Ref 2450.corr.RVBC250827

Barn at Lower Reaps Farm, Whinney Lane, Mellor, BB2 7EL

Application references 3/2025/0507 and 0508

south elevation

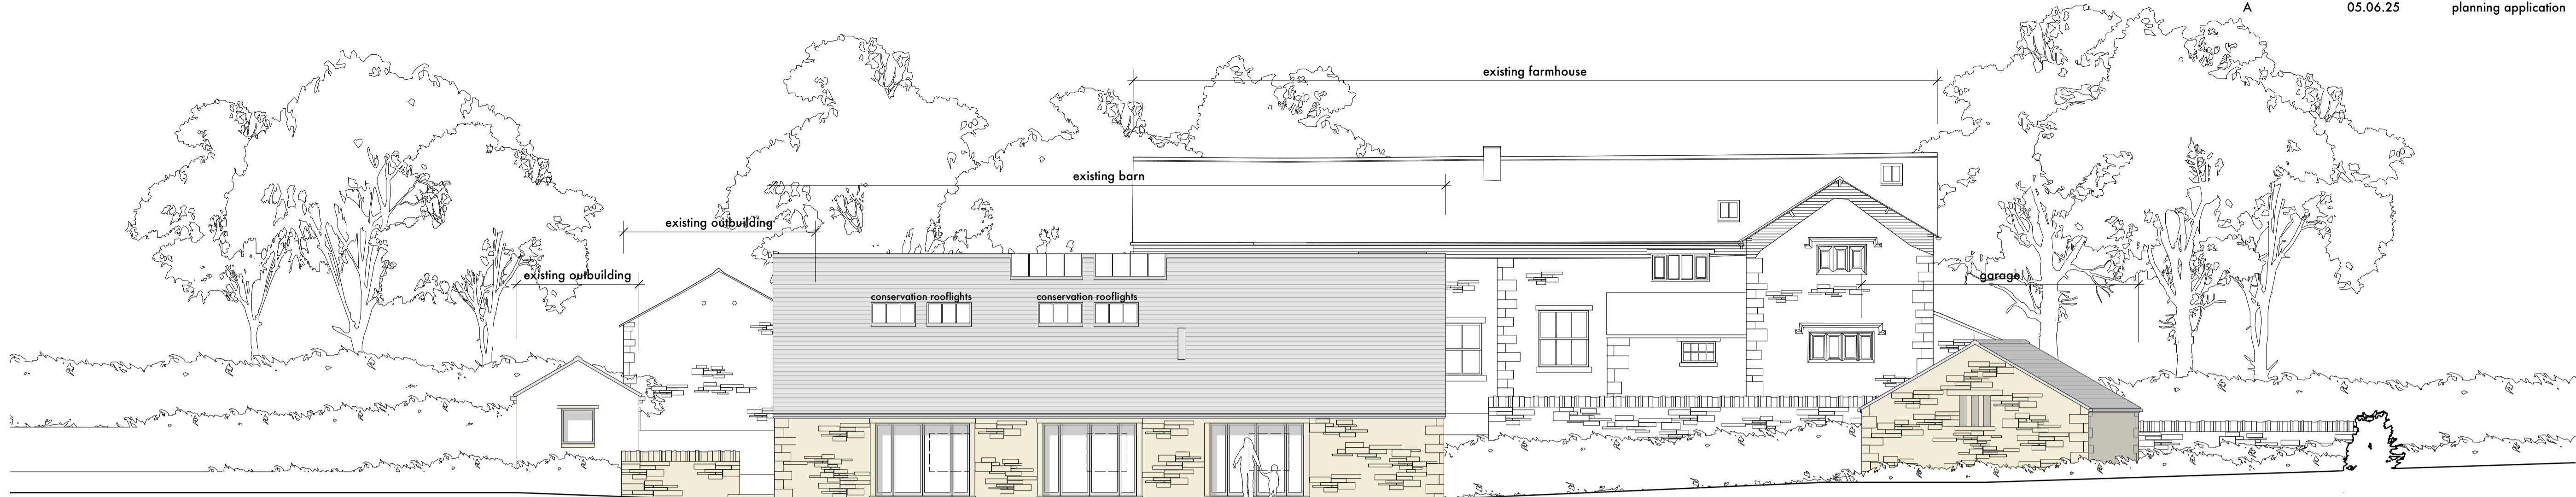
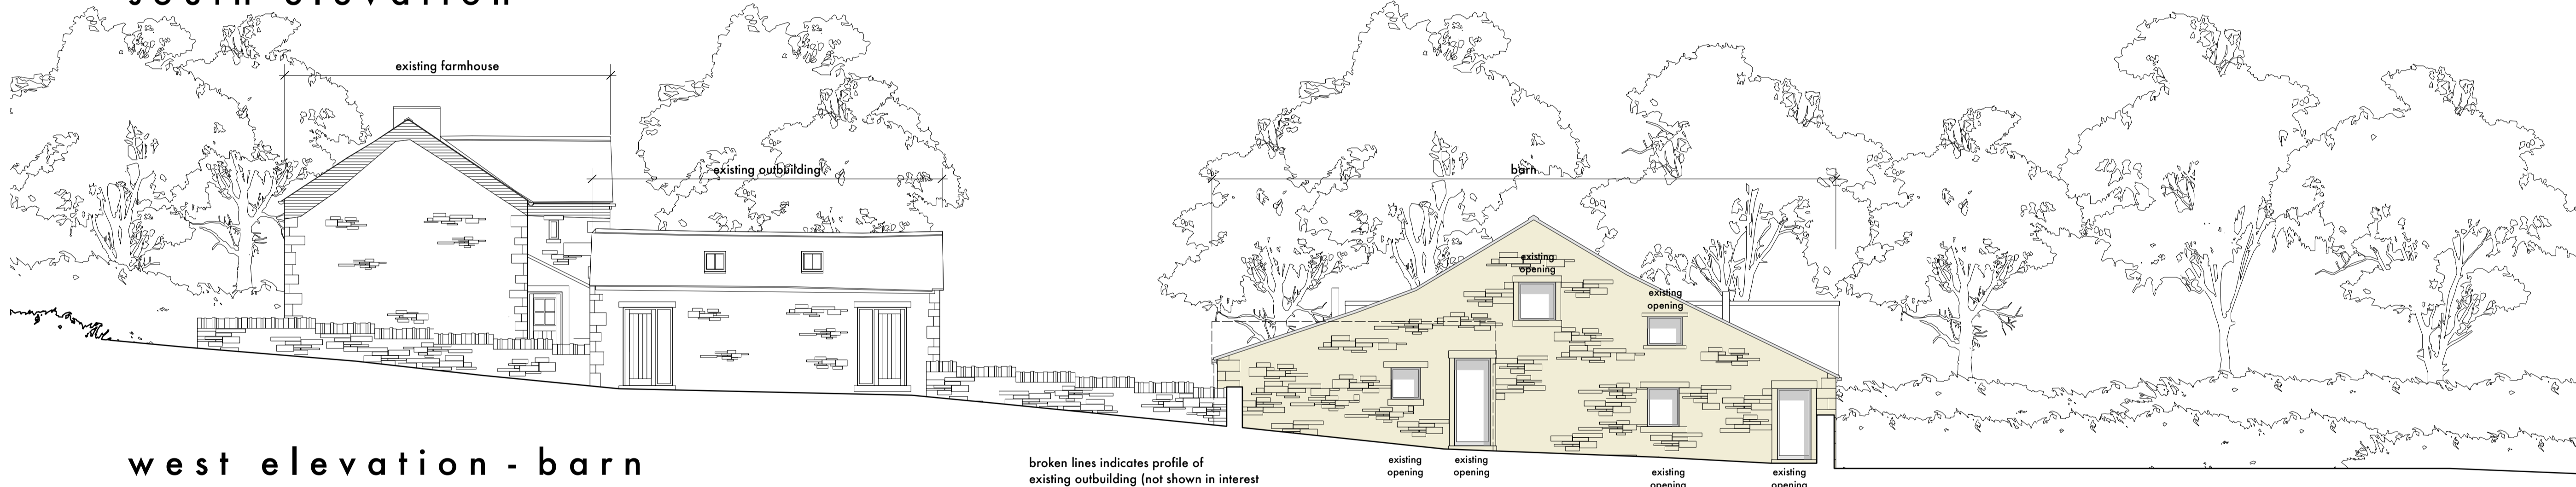
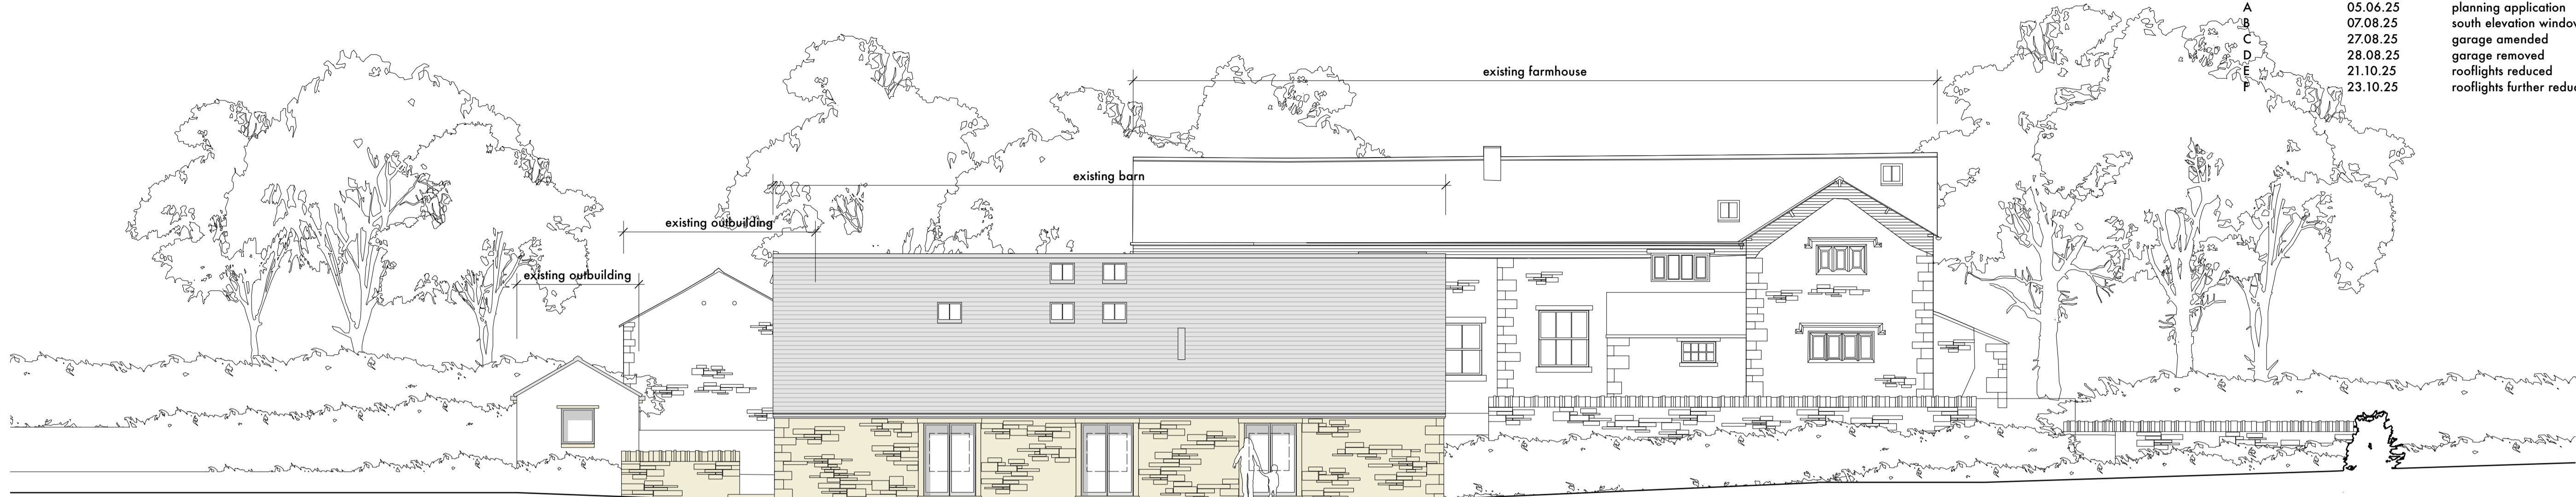
1. *'I have some concerns on the width and extent of the areas of glazing and doorways to the south elevation'.*

It is our understanding that Northern Powerhouse's comments were based on the application as originally submitted. Our correspondence dated 07.08.25 (responding to The Council of British Archaeologists' observations) commented on this matter in detail and proposed reducing the sizes of these openings - further copies of this correspondence and associated drawings are attached.
